Recommendation Report for Works to Tree(s) on trees subject to a Tree Preservation Order (TPO)

REF NO: BN/37/22/T

LOCATION: Land west of Green Acres
Lake Lane
Barnham
PO22 0AE

PROPOSAL: Various works to various trees.

Project title Land at Lake Lane Barnham, West Sussex			
Drawing title Tree Retention and Protection Plan Tree Works Application			
Scale 1:250 @A1	Drawn GS Approved JJ	Date 16.03.2022	Revision 00
Drawing No LLD1532 / 01 CAD Filename LLD1532 / CAD			Revision 00

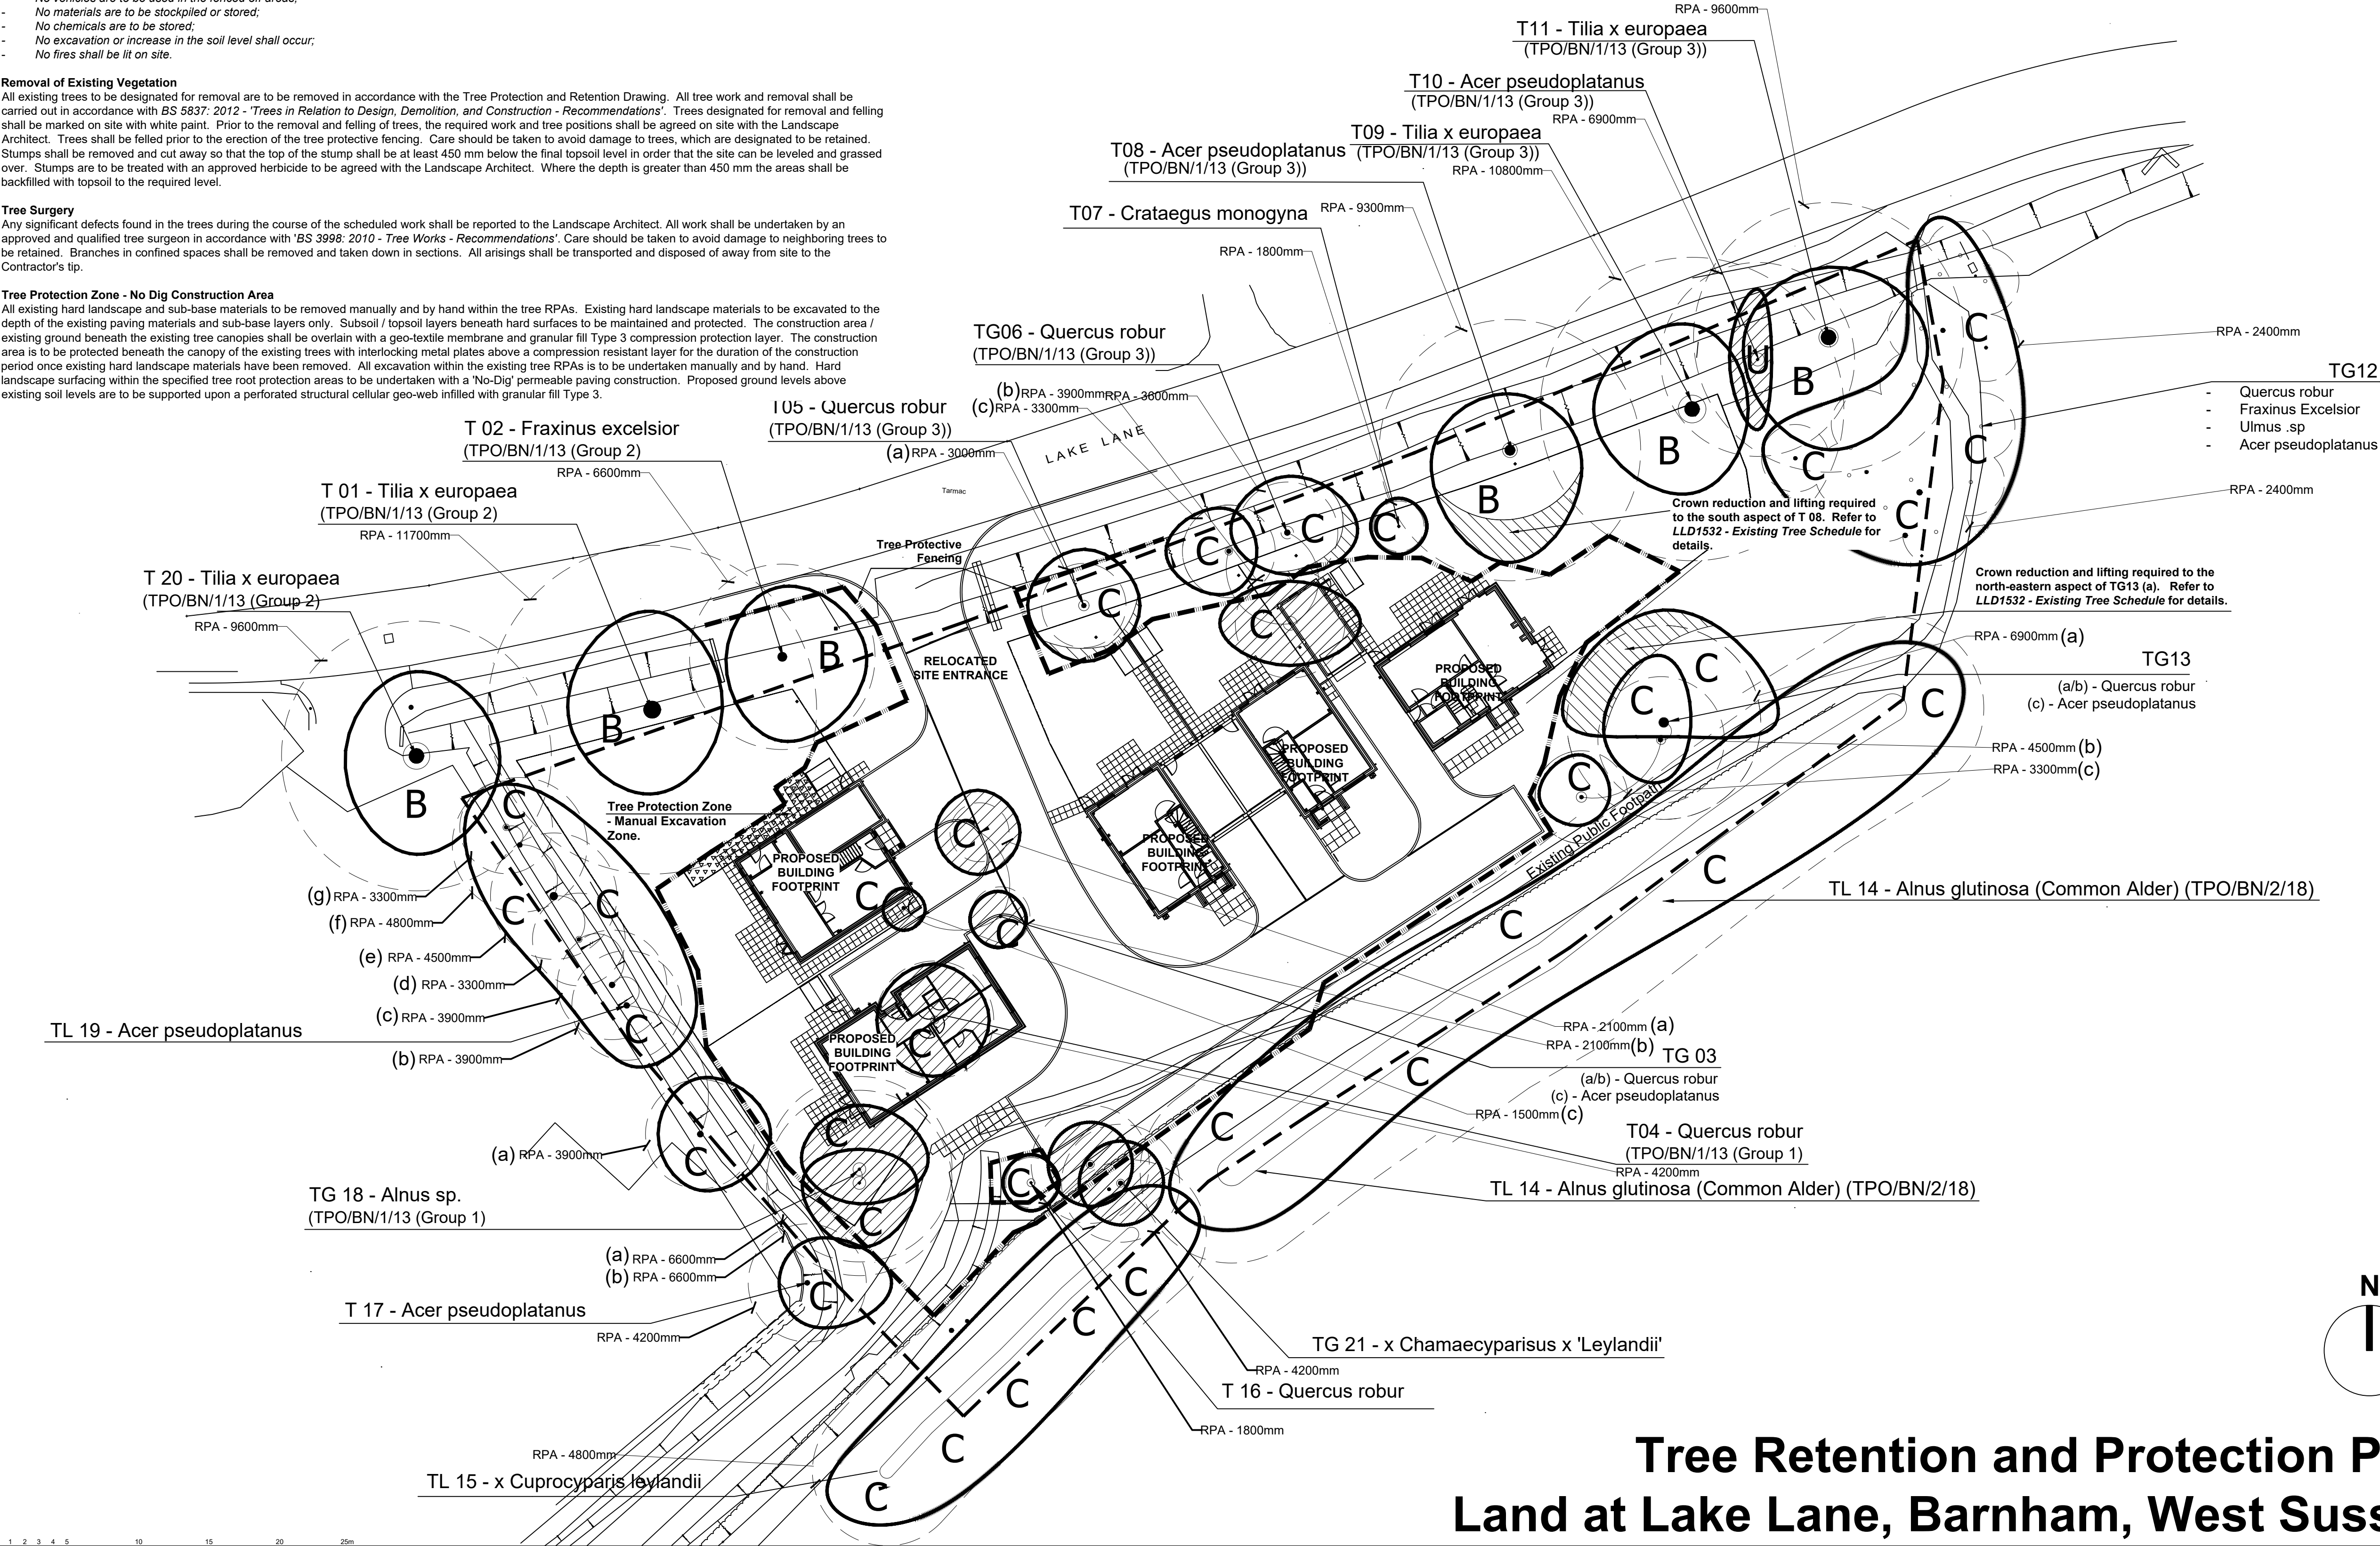
Outwardly both trees appear to be in a fine physiological state and assumed to be so in the absence of any evidence provided to the contrary.

The applicant/agent has submitted a tree survey and plan. Those are comprehensive and include detailed work specification with satisfactory reasons given for each item.

The work proposed is justified on arboricultural grounds due to the proximity of branches to newly constructed dwelling and encroachment over garden area.

A large wound is to be created near the base of T08 which is contrary to the requirements of BS3998:2010 Tree work - Recommendations. Retention of some length of the limb and subordinate branch structure would be preferable if practical to do so. It is vital that the work is undertaken to a high standard (position of final cuts) and at the right time, to minimise adverse effect on the tree's long-term vitality and visual amenity.

I recommend CONSENT is granted subject to the following condition.

- 1 Where whole branches are to be removed and final cuts made close to the trunk or branch union they are to be made as shown in Figure 2 of BS3998:2010

Where branches are to be shortened back the final cuts are to be made at the correct angle shown in BS3998:2010 and adjacent to a live bud or lateral.
